Attn. : Jeff Palmer – Code Enforcement Supervisor  
Cc. : Hannah Aulick and Reviewers  
Re. : SI-2024-00597 – SITE PLAN DFT  
 : 2026 Central SW  
Project No. : PR-2023-009688

I apologize for my lack of quality control on the last submittal as some of the items were on the drawings however on non-printing layers. We have prepared individual responses to each of your previous comments that did not receive clear and complete responses and verified that those responses are clearly reflected in the plots being submitted to you.

The architect has been advised by the City that this information is for informational use only and is not to be used for any other purpose.

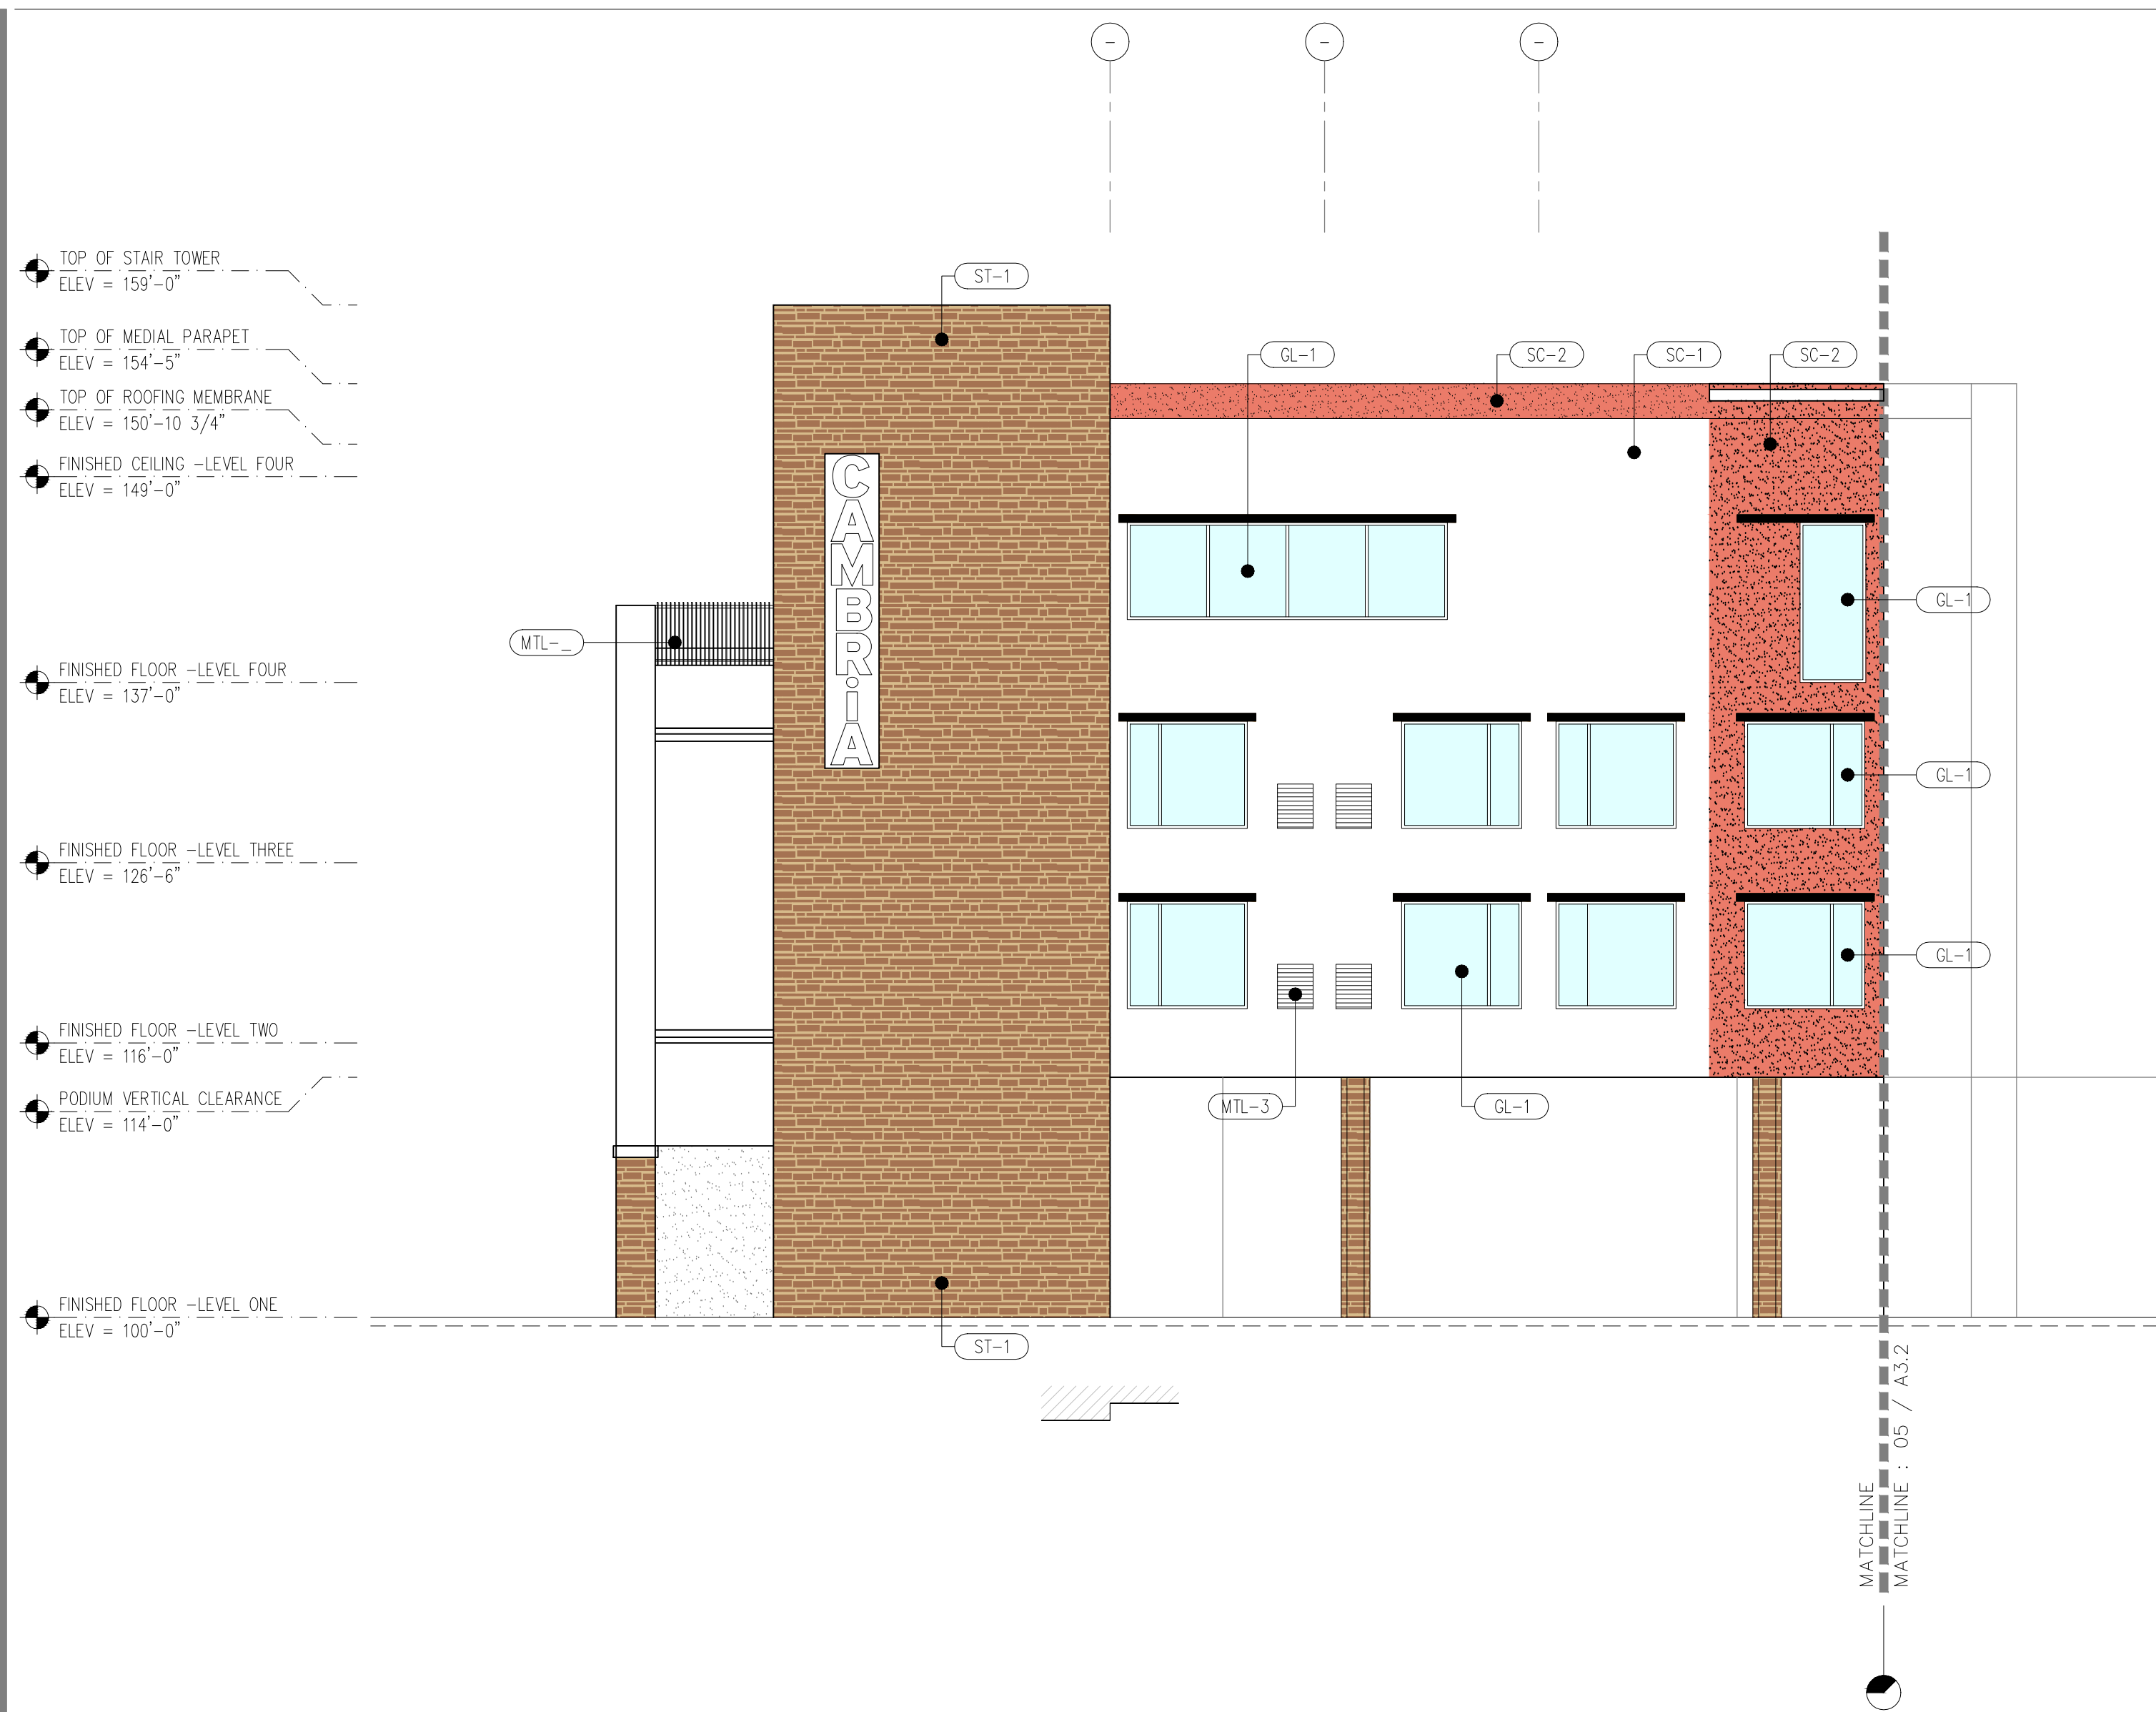
- 12 *Comment* - 5-5(G)(3)(b) No horizontal length of any façade shall extend longer than 40 feet without the inclusion of architectural elements such as decorative grillwork, louvers, translucent screens, alternating building materials, projection of lintels, portals, and other external features to avoid visual monotony. A change in color alone does not satisfy this requirement. Confirm compliance.

*Response: Concur. The elevations have some lintels shown, but we have added some other architectural elements in the stretches of elevation that are more than 40' to avoid visual monotony.*

01 ENLARGED FRONTYARD SITE AREA

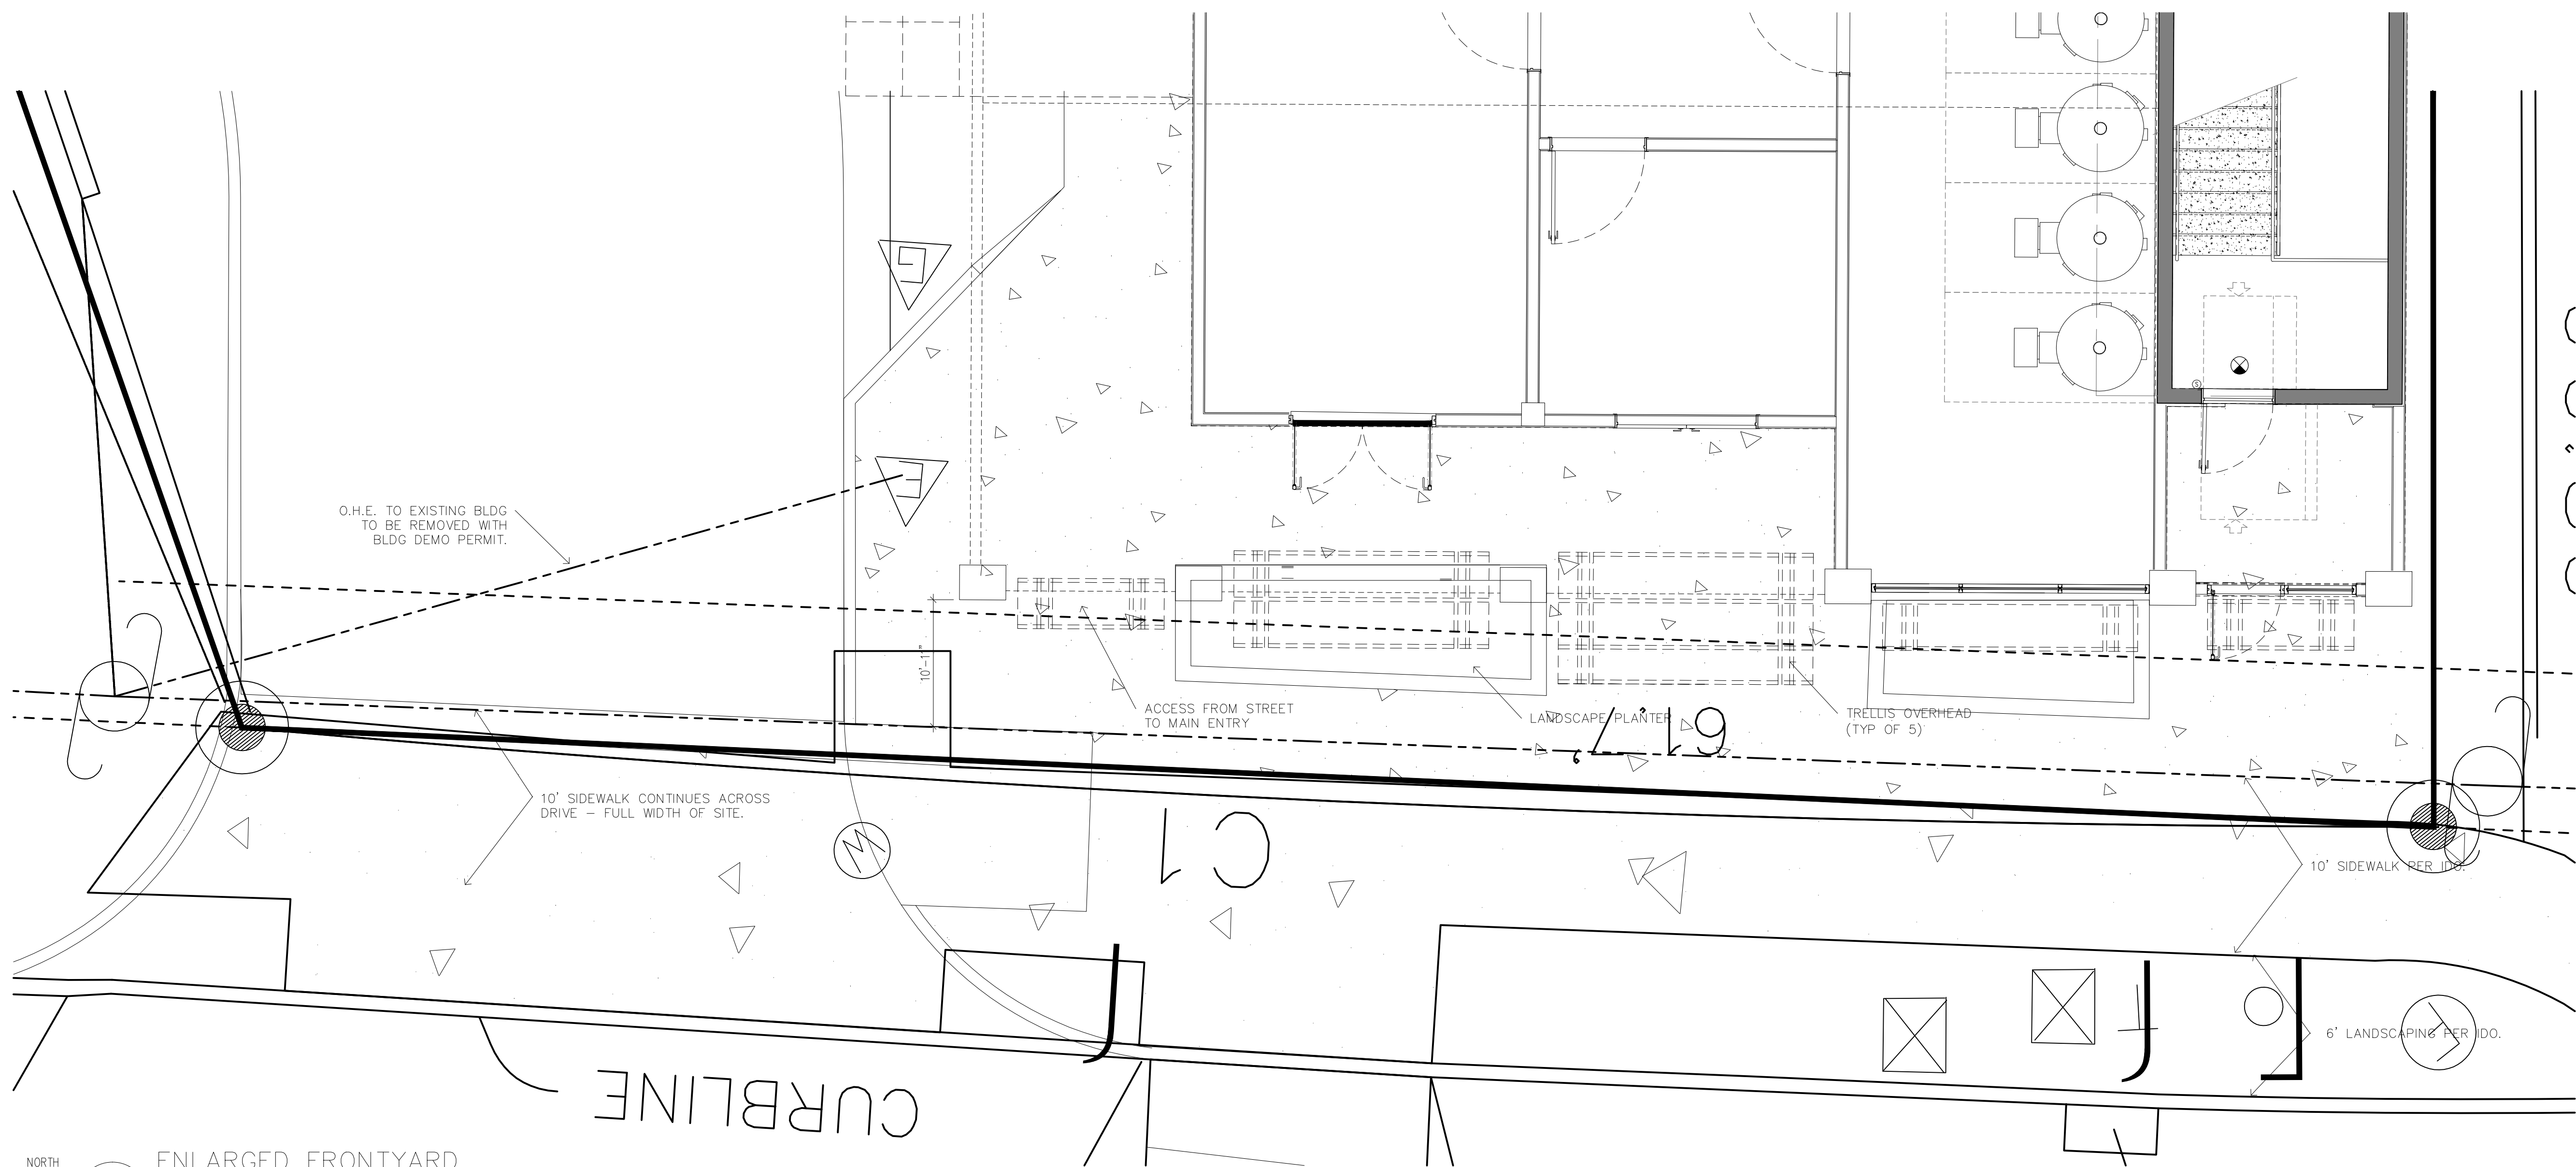
3 **Comment** -Please show calculations and/or measurements on site plan to show how you are meeting unique requirements for Urban Center, Main Street and Premium Transit Areas, IDO 5-1(D)(2), regarding (a) setback in relation to sidewalk width and (b) percent of

- 8 *Comment* - IDO 5-3(D)(2)(b) Reference DPM 7.2.29 for Sidewalk/landscape buffer widths. Parcel is outside of a Center. This location on Central is within a Premium Transit Station Area, a Major Transit Corridor, and a Main Street Corridor. Therefore, Central requires an 8–10-foot sidewalk and a 6–8-foot landscape buffer. Provide widths of existing features on the landscape plan to match the site plan and show street trees in the landscape buffer.

*Response: An enlarged area plan has been provided that illustrated the manner in which the project meets the unique requirements for UC, MS and PT Areas, IDO 5-1(D)(2), regarding (a) Setback in relation to sidewalk width and (b) percent of front property line occupied by front building.*

*Response: An enlarged area plan has been provided that illustrated the existing features at the front property line that coordinates with the landscaped plan.*

2 TREE PLANTING DETAIL

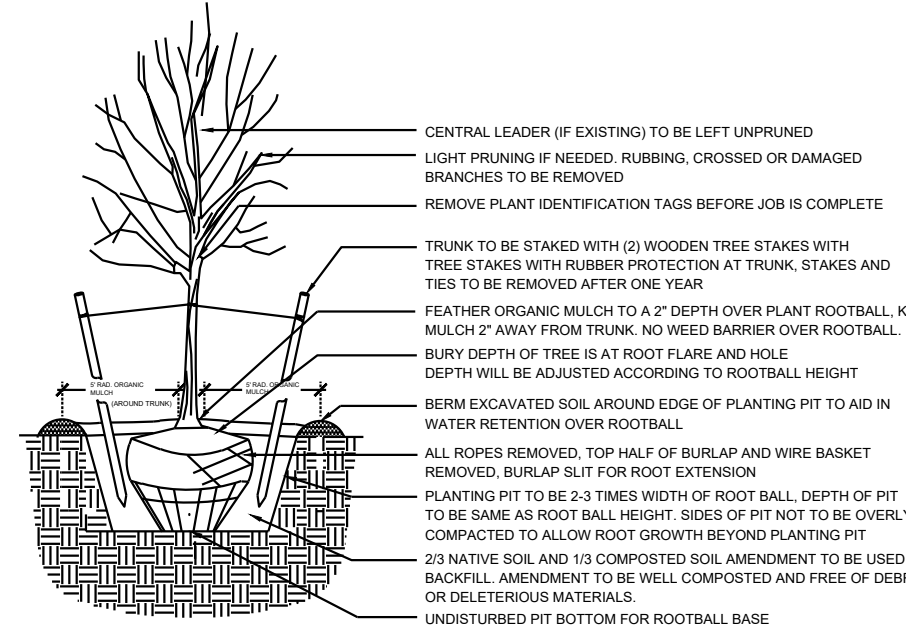
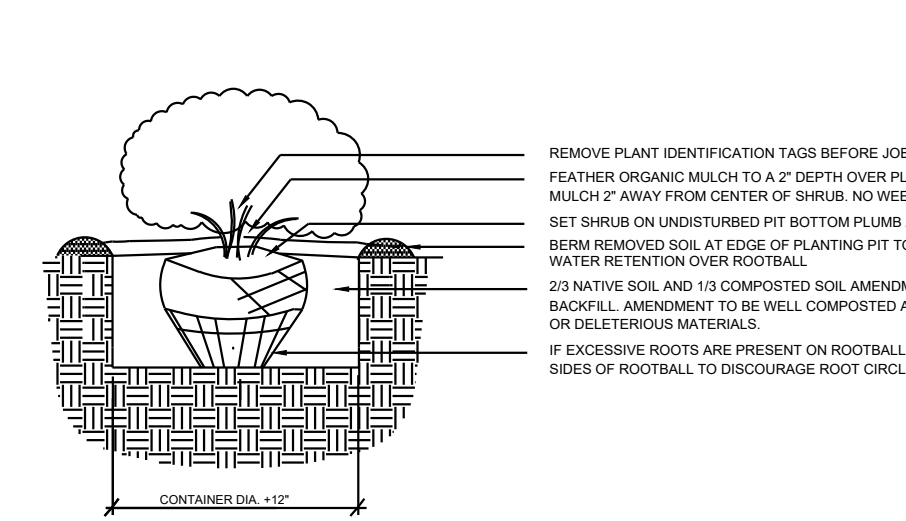
*Per 5-6(C)(5)(e), organic mulch is required as ground cover under trees within a 5-foot radius around the tree trunk, but not directly against the trunk. In these areas, weed barrier fabric is prohibited. (See figure below.) Modify your tree planting detail to reflect this requirement. The organic mulch used under the trees can be counted towards non gravel mulch used on the site as discussed earlier under 5-6(C)(5)(c). Please make sure you are mention 'Organic Mulch' on your planting details.*

**Response: See attached landscape drawings.**
